From: [Tom Leonard](#)
To: [Deb Estrada](#)
Cc: "[Marianne Leslie \(mleslie.llddev@gmail.com\)](mailto:Marianne.Leslie@mleslie.llddev@gmail.com)"
Subject: Comments of Concern RE: SUB19-002 EAST SEATTLE SCHOOL SUBDIVISION
Date: Sunday, January 21, 2024 4:11:12 PM

Comments of Concern for SUB19-002 East Seattle School Parcel Subdivision

PRELIMINARY ROAD PLAN & SECTIONS
2825 W MERCER WAY
PRELIMINARY PLAN
PARCEL #2174502425
CITY OF MERCER ISLAND WASHINGTON

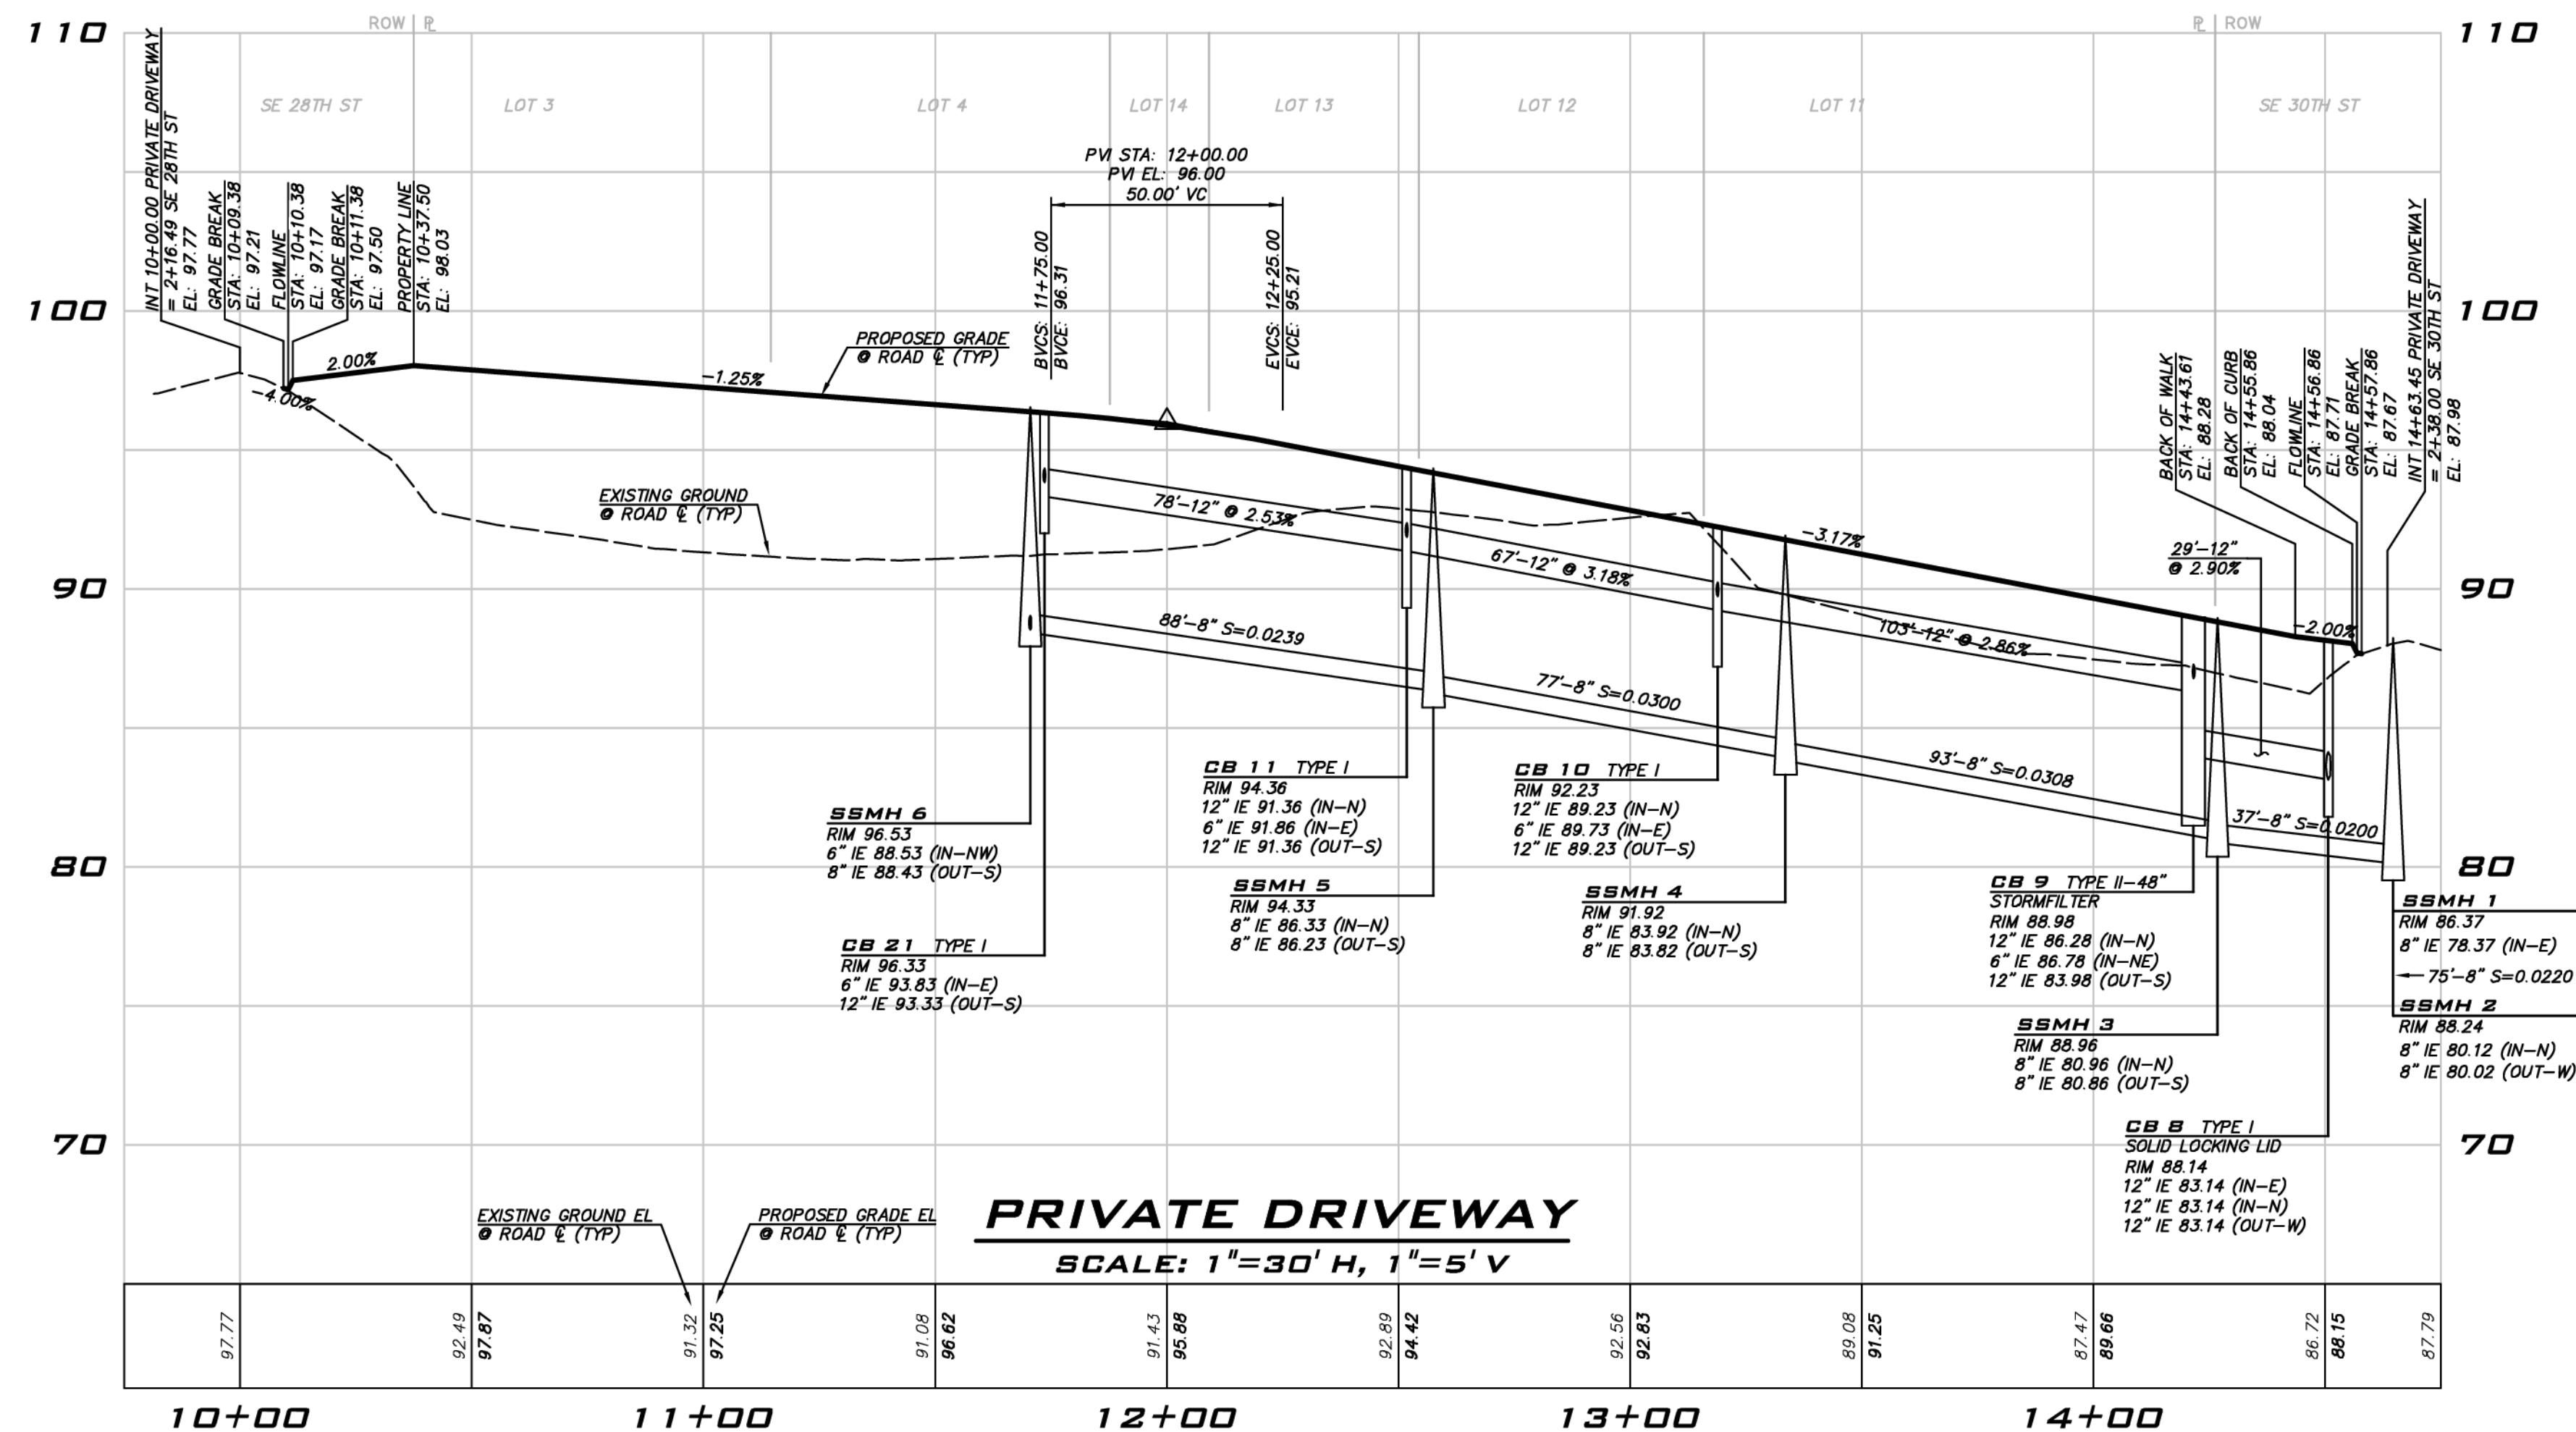
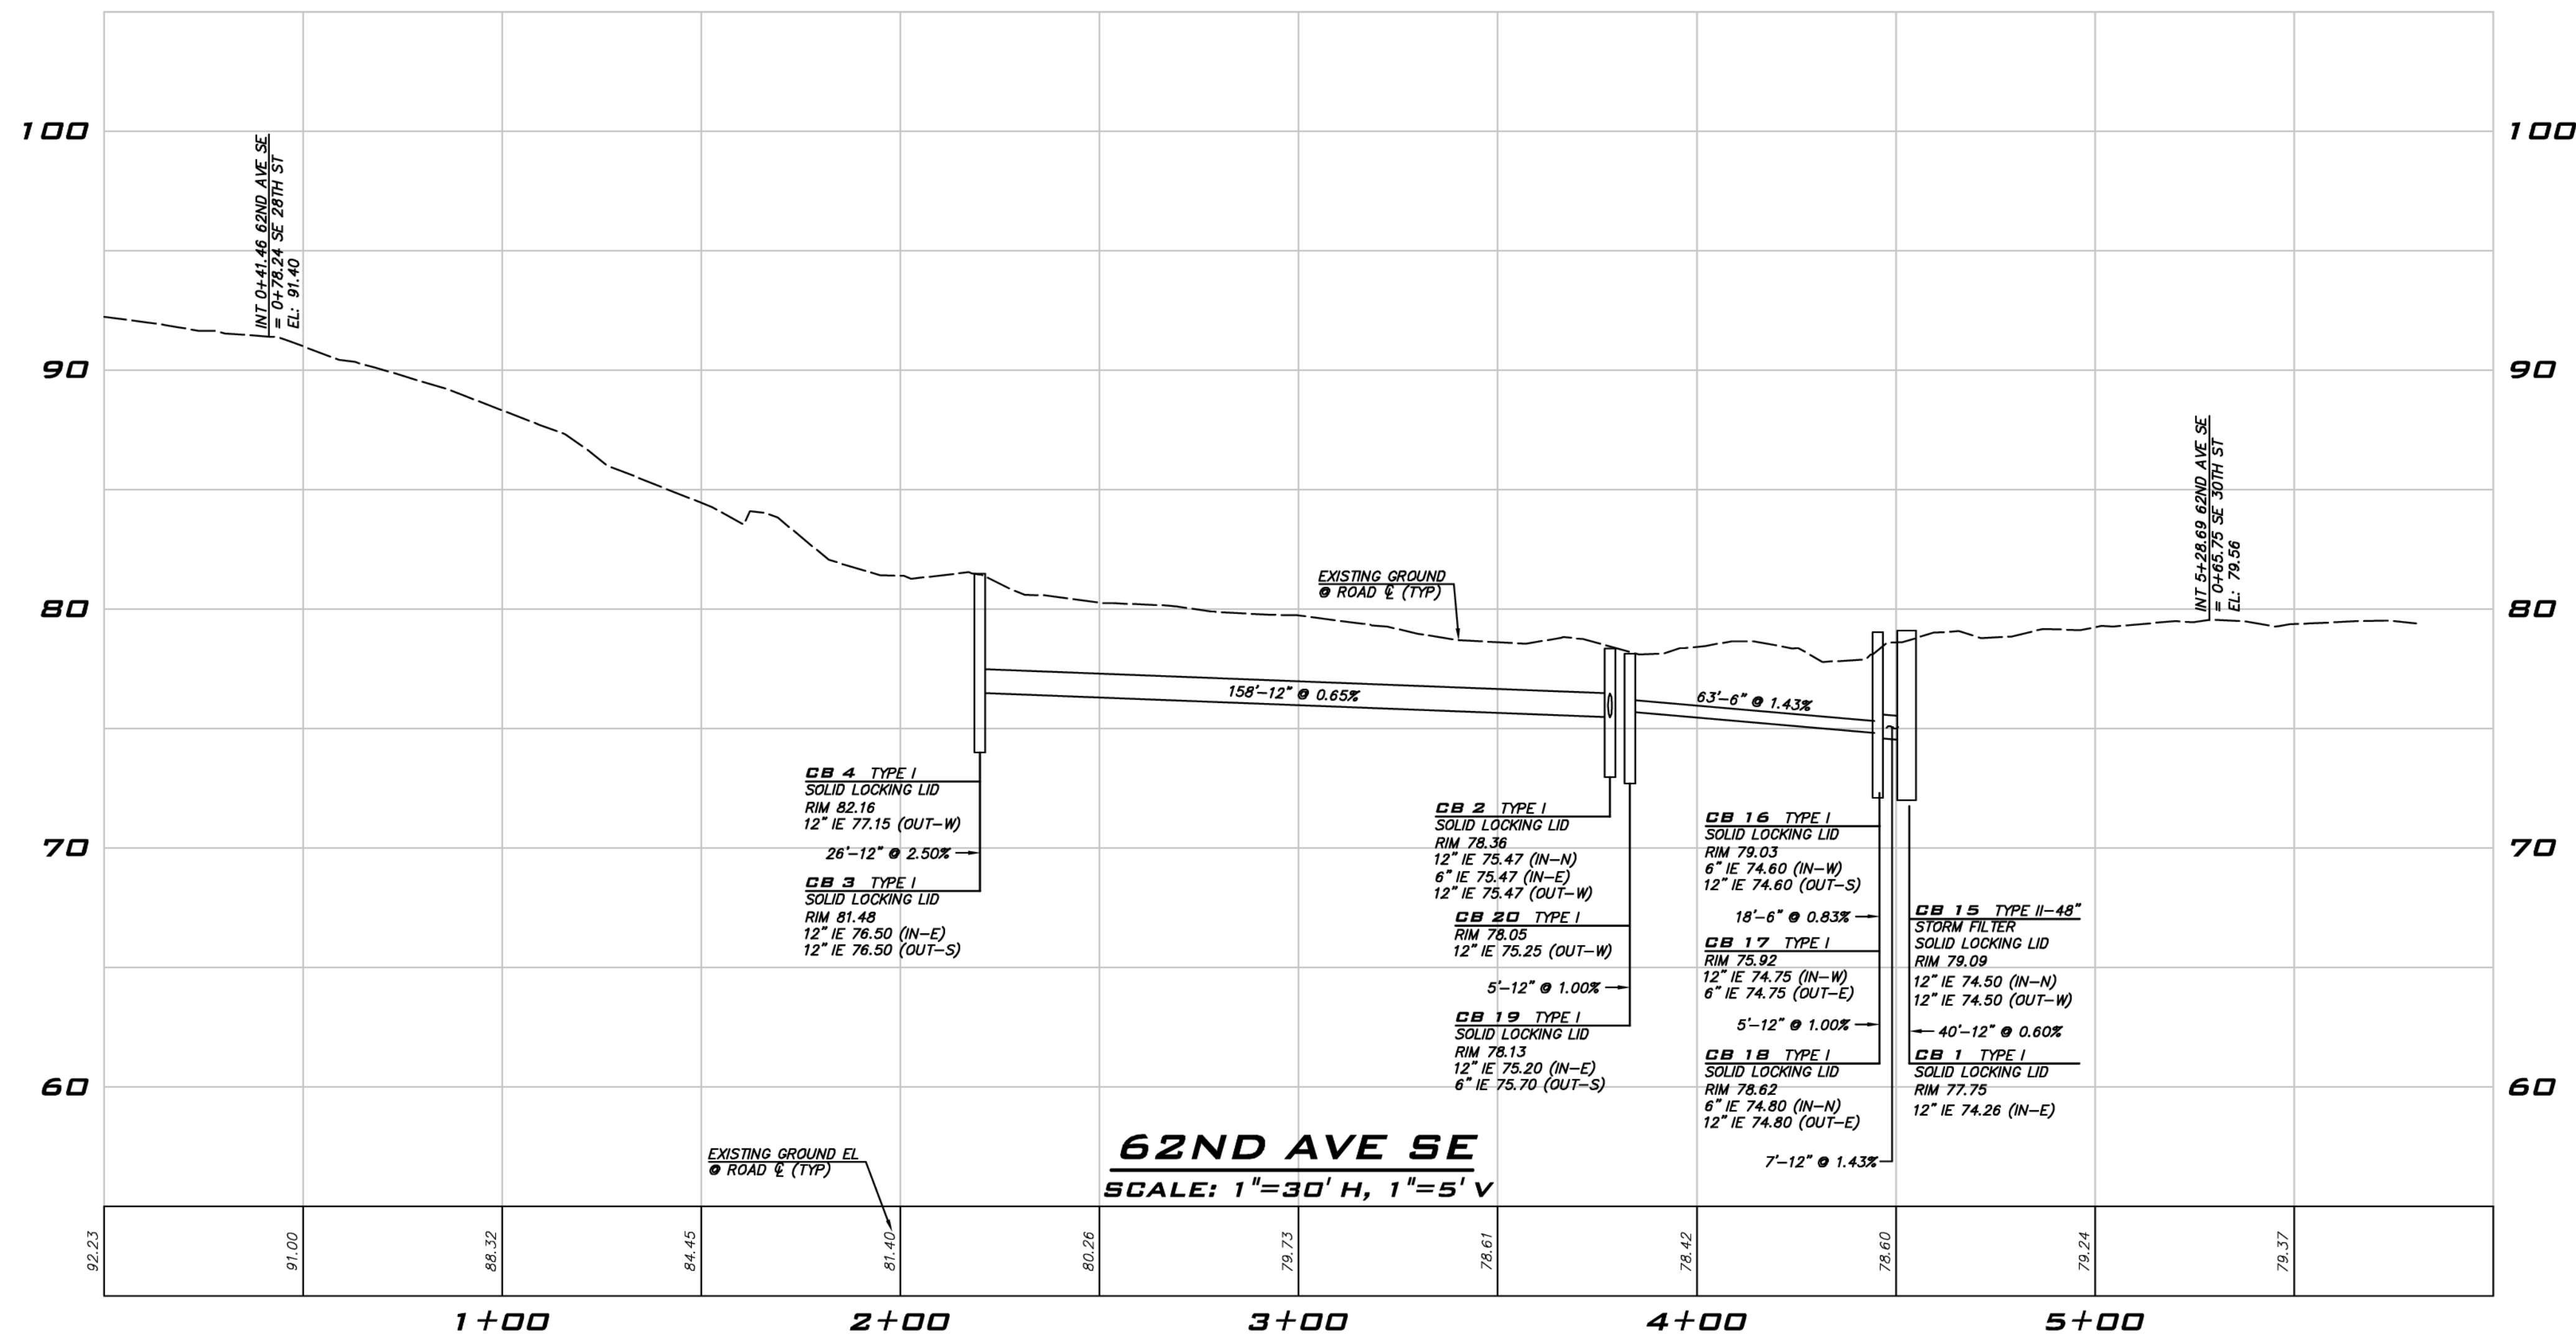
4. We believe that all driveways for individual homes should be inside the development and not exit onto the public roads. The center "Private Driveway" should be designed to provide this.
5. There are very few Street lights in our community. Any street lights should be low in height

7. As a Long Plat, it seems there should be sidewalks required around the development along the public roads.
8. It appears that underground utilities are being required and that is good. Having 13 or 14 homes with a forest of poles and wires above ground in this era would be an eyesore and a mistake.

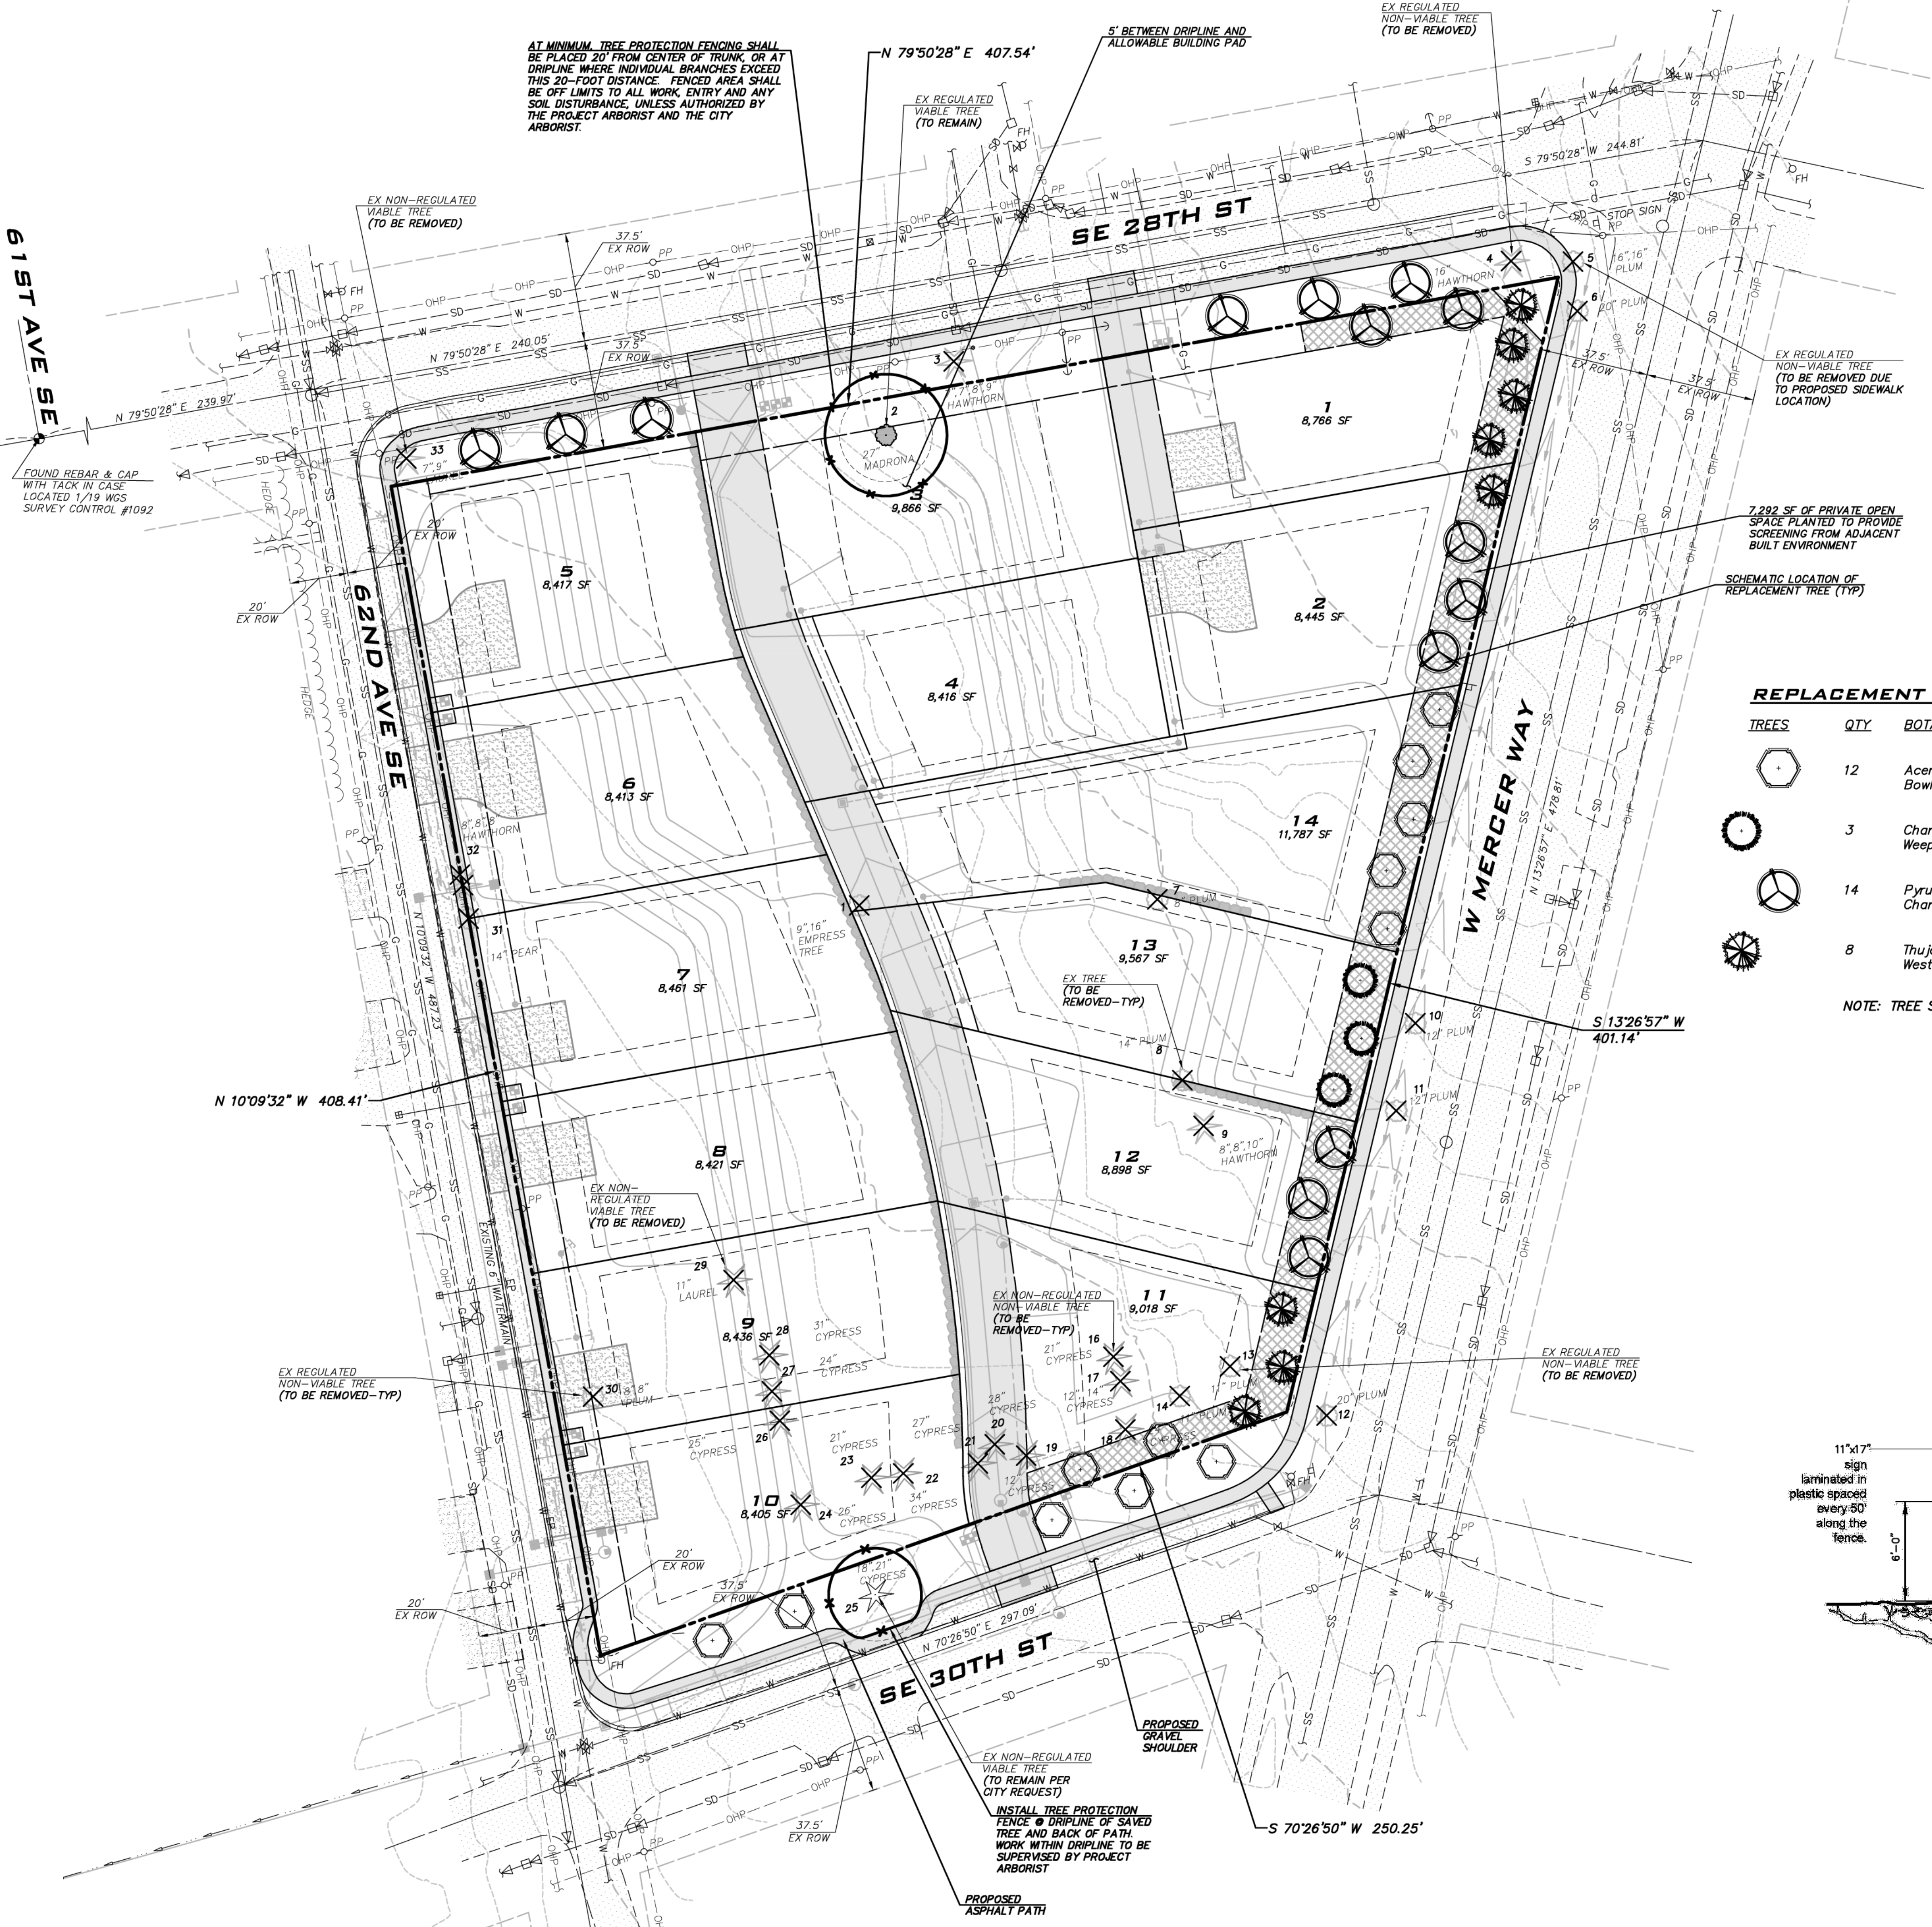
3. **Vegetation** on finished lots, along the perimeter and along West Mercer should not be allowed to have mature heights over 25 feet. Provisions calling for periodic review of those heights and remediation to maintain a "not greater than" status of all structures and vegetation should be called out. This is essential View Protection.

The current plan calls for trees to be planted that surely will compromise the views for our home and our neighbors to the east of this project. We suggest a hedge system along West Mercer instead of trees and dwarf trees along the private driveway in the development. At least assure vegetation along West Mercer does not become a view blocking wall of trees by specifying that trees shall not be of a species that will mature with more then 25 feet height. Further, providing view protection enforcement to those on the east side of this development to the above height standard should be included.

9. If ADU's are permitted, additional parking within that lot should be required.
10. The planned approach to allowing 36 of 37 trees to be removed all at once is really clear cutting. Those trees absorb a great deal of water and that runoff will get worse. These facts and the lack of treatment for the water is environmentally outlandish.
